Date: 24/08/2021
Our Ref: PPA0005981

Site Address: Rover Way, Splott, Cardiff

Development: 2D - The Removal of Fill Material and the Construction of Industrial Accommodation (B8 Use Class), New Access Roads and Associated Landscaping Works

00 - Proposed Site Plan
1 : 2000

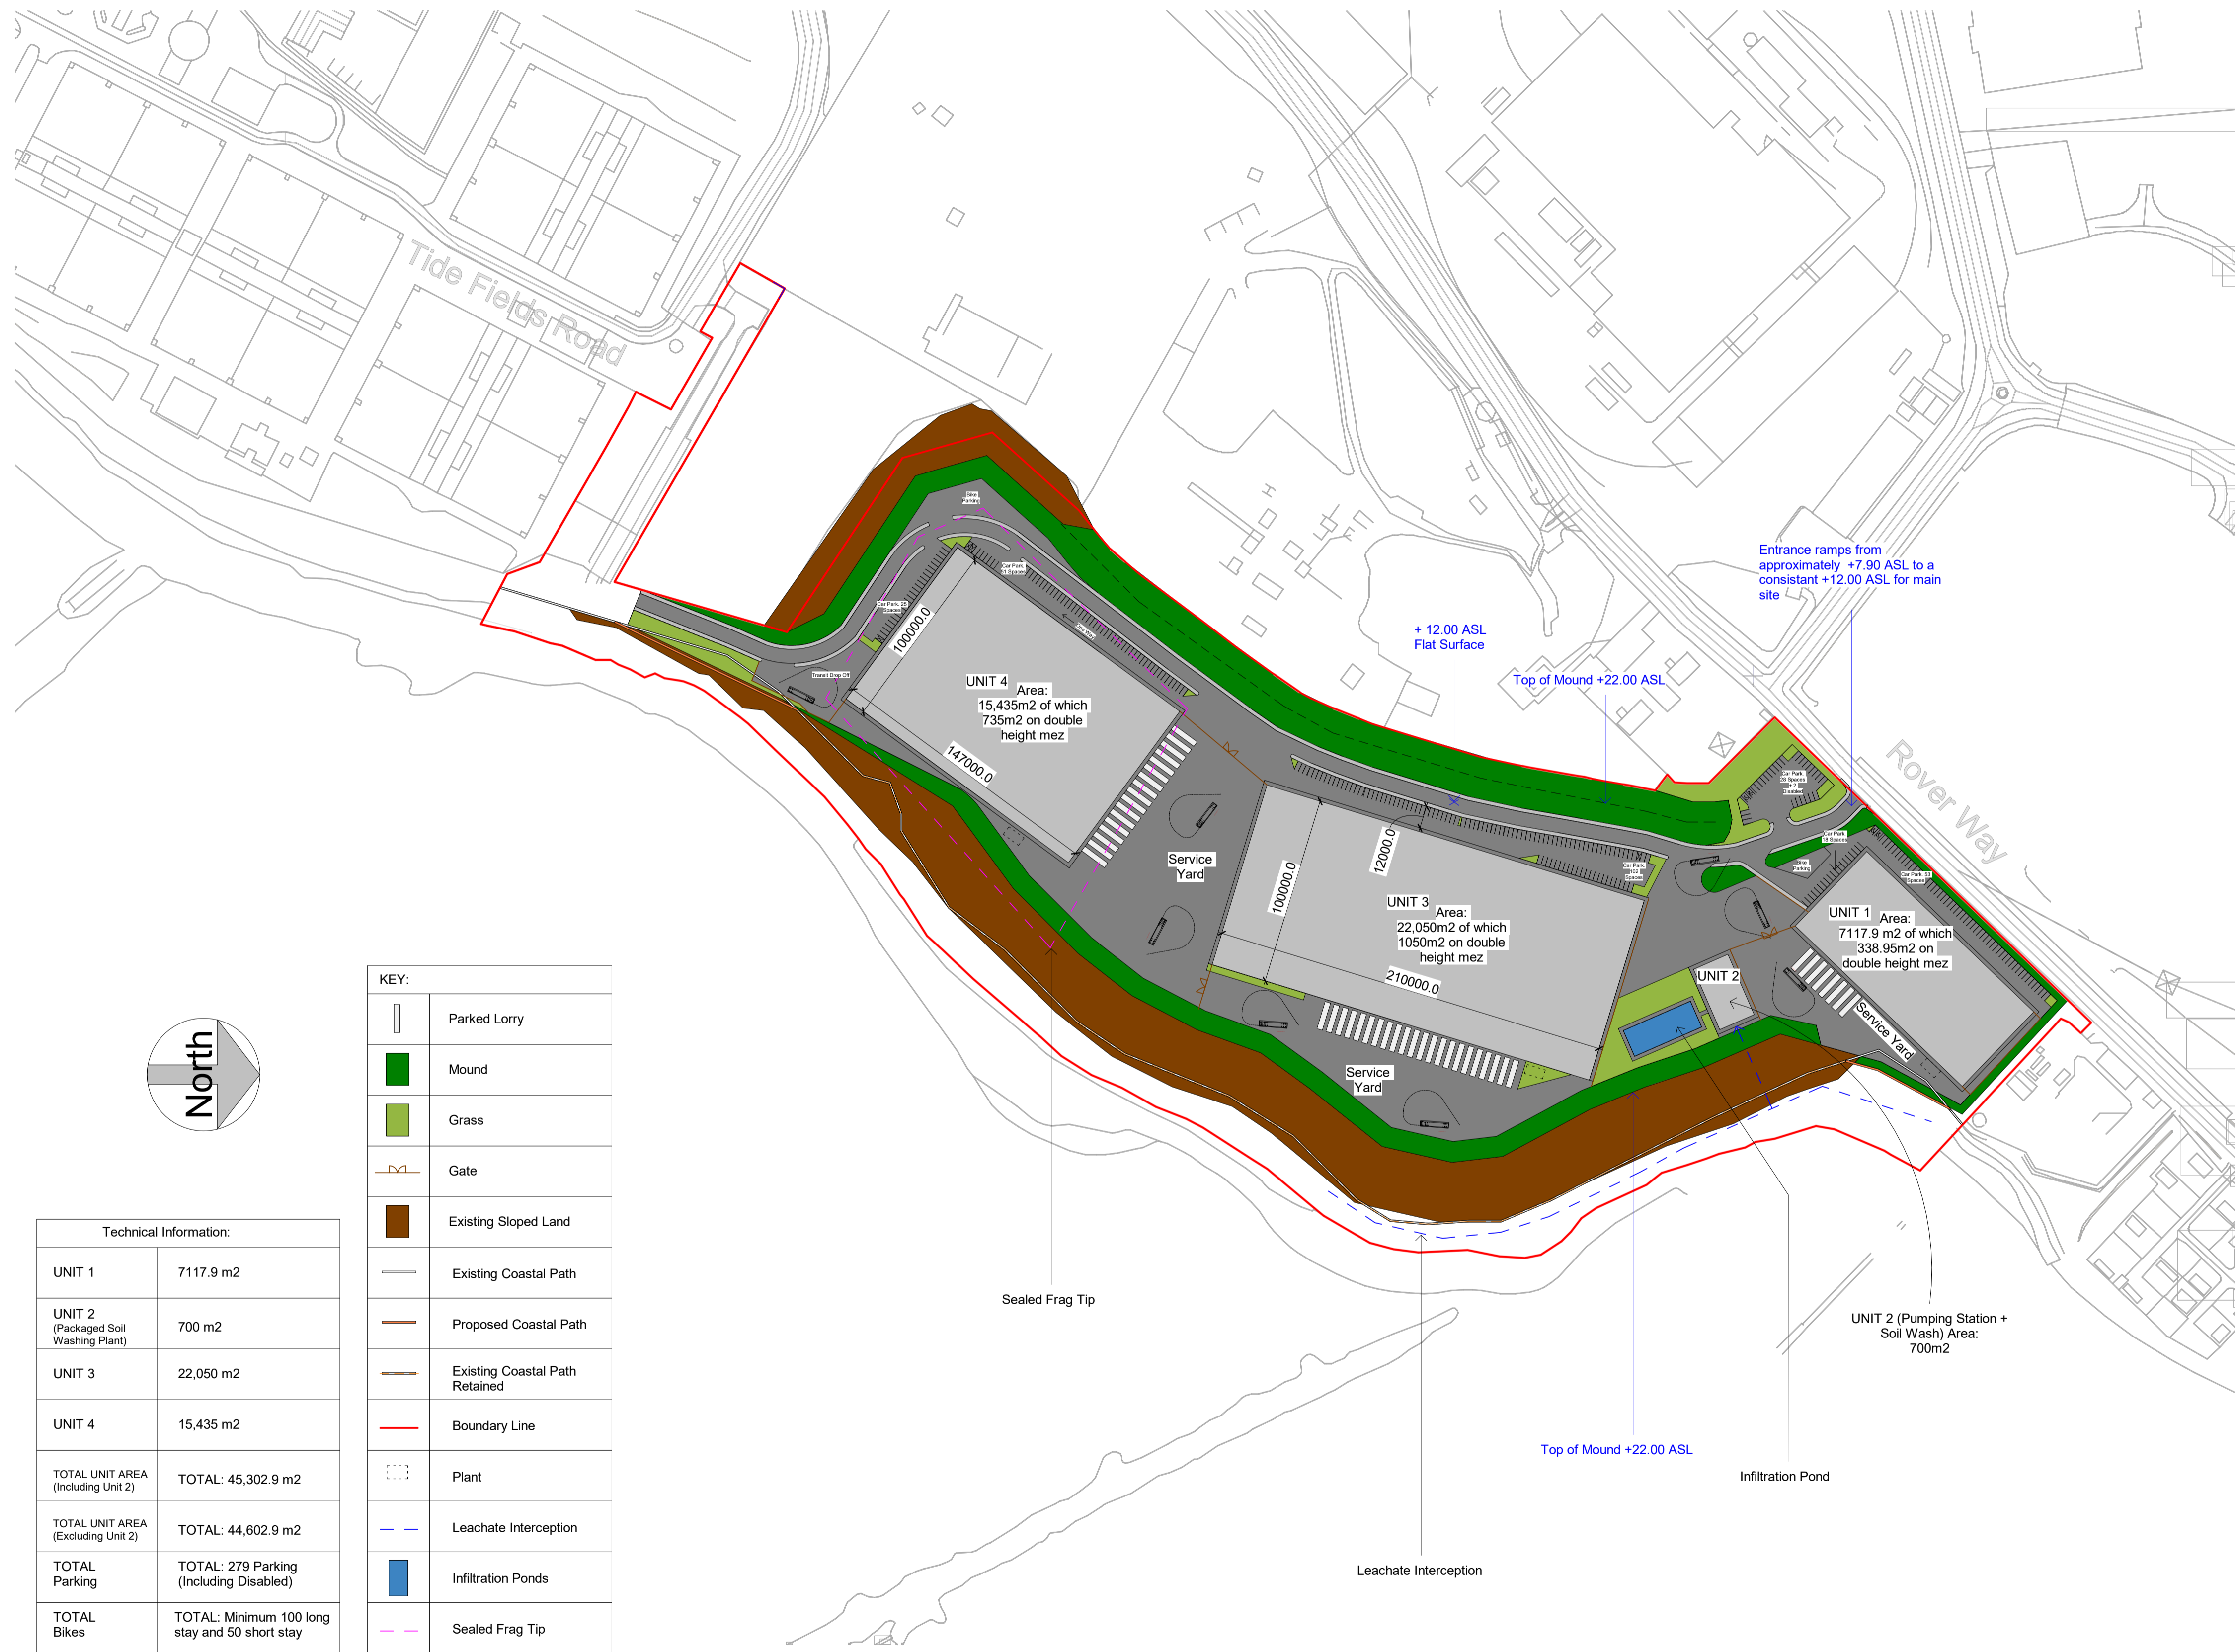
However, having regard to the Proposes Site Plans, it appears the proposed development would be situated within the protection zone of these strategic assets.

Given the size and strategic nature of these assets we advise we would not permit for any of these existing public sewers to be diverted. Therefore, we recommend the proposed development is repositioned to accommodate for the required protection zones. In the first instance, it is recommended that the developer carry out a survey to ascertain the location of this sewer and establish its relationship to the proposed development.

- 12 metres either side of the centreline of the 2400mm public combined sewer
- 12 metres either side of the centreline of the 2500 public combined sewer overflow
- 8 metres either side of the centreline of the 1850mm public combined sewer
- 7.5 metres either side of the centreline of the 1500mm public combined sewer
- 6 metres either side of the centreline of the 1200mm public surface water sewer
- 6 metres either side of the centreline of the 1065mm public surface water sewer
- 4.5 metres either side of the centreline of the 900mm public surface water sewer
